Application Reference: 2025/0157

Site Address: Greenlands, Lundhill Road, Wombwell, Barnsley, S73 0PG

This application seeks full planning permission for a Single storey side extension to dwelling for use as a garage, located at Greenlands, Lundhill Road, Wombwell, Barnsley, S73 0PG.

Drawing No.	Rev No.
MJW001 -003

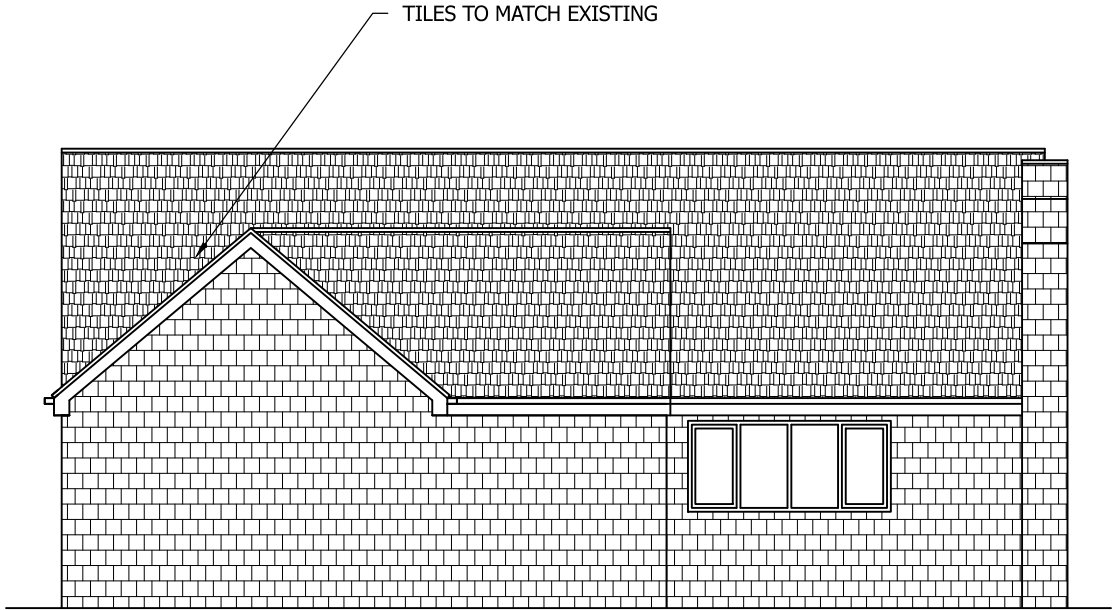
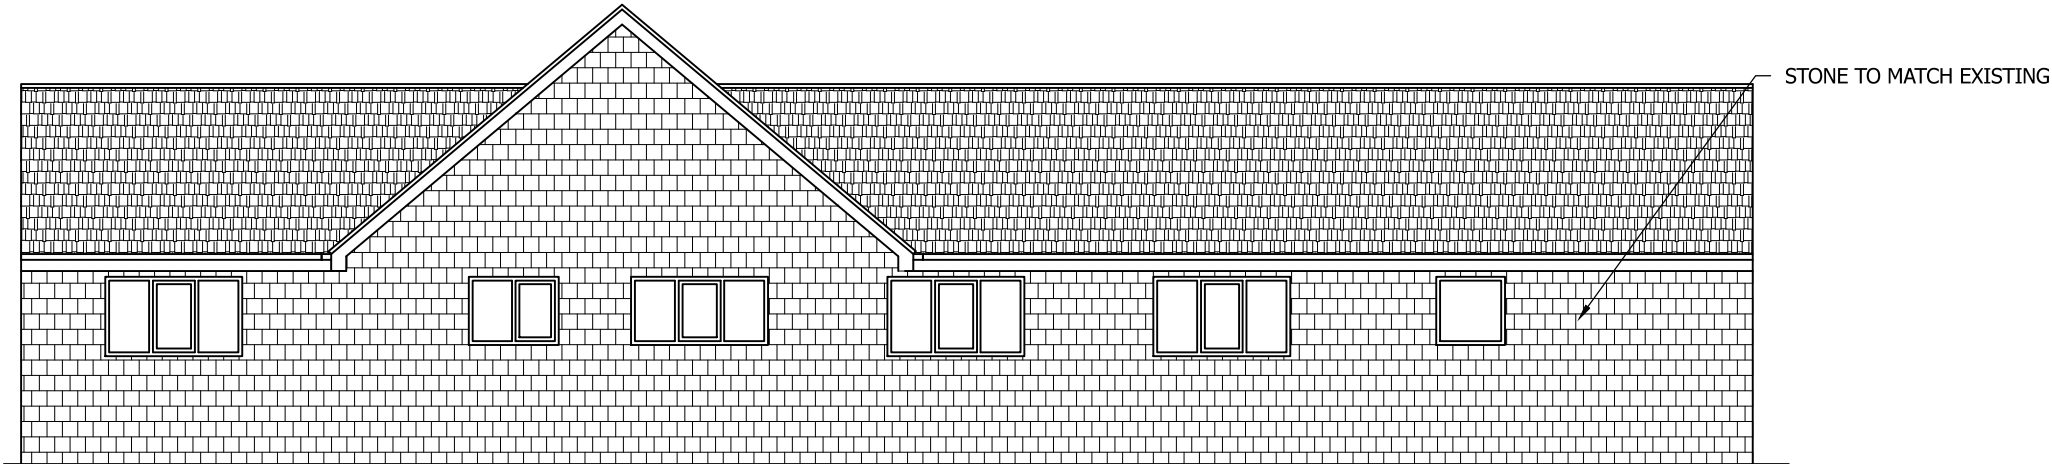
The scheme is to provide a garage for the existing dwelling which is a bungalow. There is no need to create a step back or create a reduced roof ridge line as it is an isolated bungalow property and thus there is no possibility of it causing a terracing effect.

The applicant has stated that the materials would match the existing dwelling and as such would reflect the existing design/ character and would not look out of place. Therefore, as a result of the comments above, the impact on the visual amenity of the dwelling and the street scene as a whole would be maintained, in accordance with Local Plan Policy D1 and the requirements of SPD 'House Extensions and Alterations (2024).

Drawing No.	Rev No.
MJW001 -004

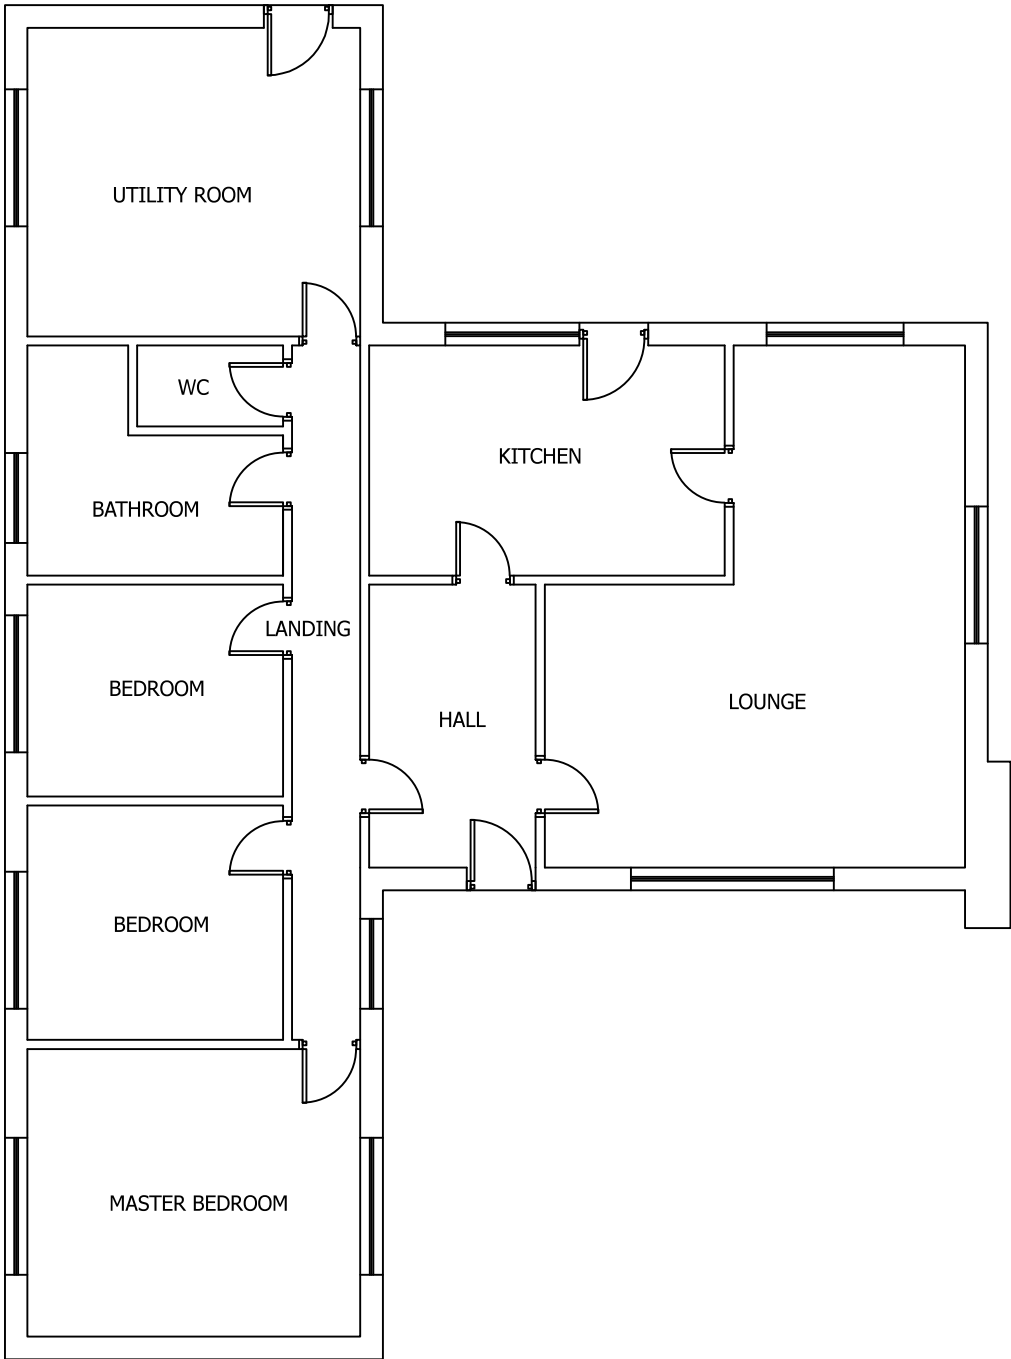
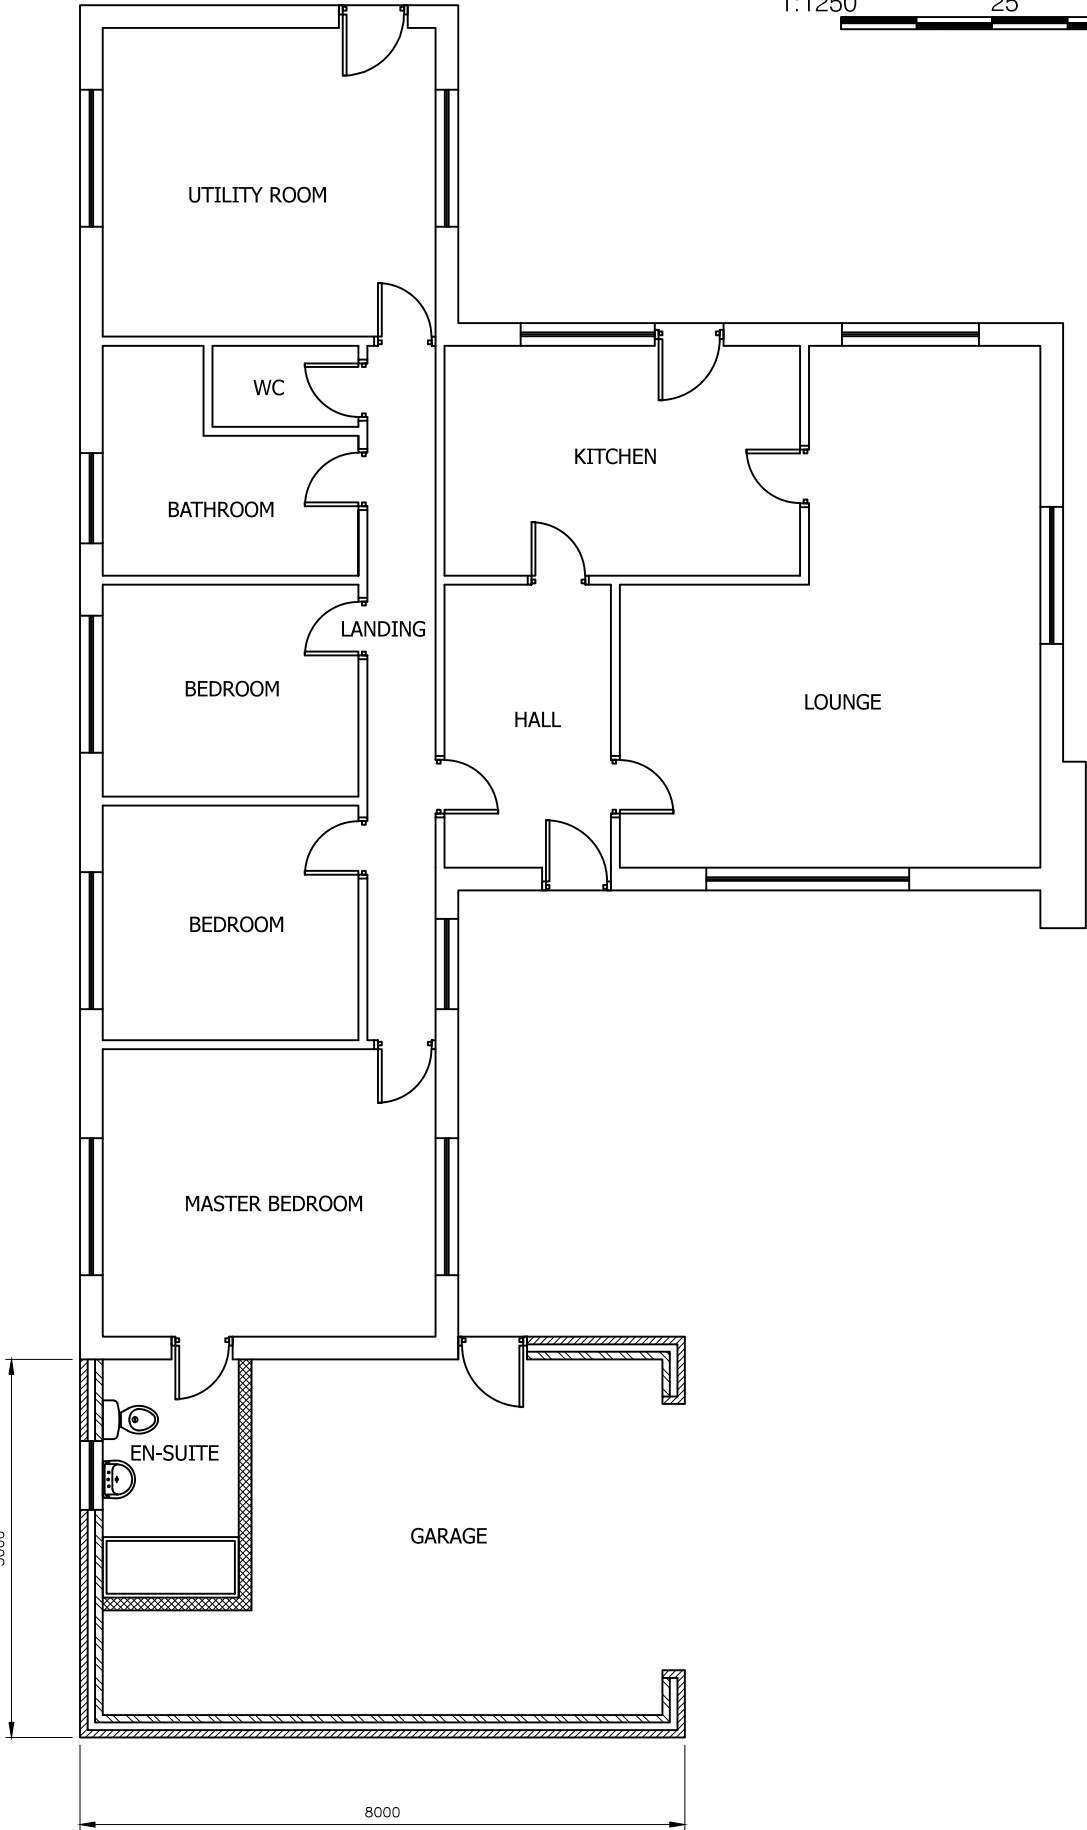
Floorspace will be calculated by external measurement of the building and floorspace within roof spaces will not be taken into account. Outbuildings will only be taken into account when calculating the cumulative additions to the original dwelling.

Original dwelling = 153.58m²

Proposed additions = 41m²

Total existing and proposed = 194.58m²

The total cumulative additions would not exceed the size of the original building by not amounting to more than a doubling, in accordance with Policy GB2 and paragraph 154(c) of the NPPF. Considering the above, this is considered to weigh significantly in favour of the proposal. The proposal is therefore considered to comply with Local Plan Policy GB1: Protection of Green Belt and Local Plan Policy GB2: Replacement, extension and alteration of existing buildings in the Green Belt and is considered acceptable.
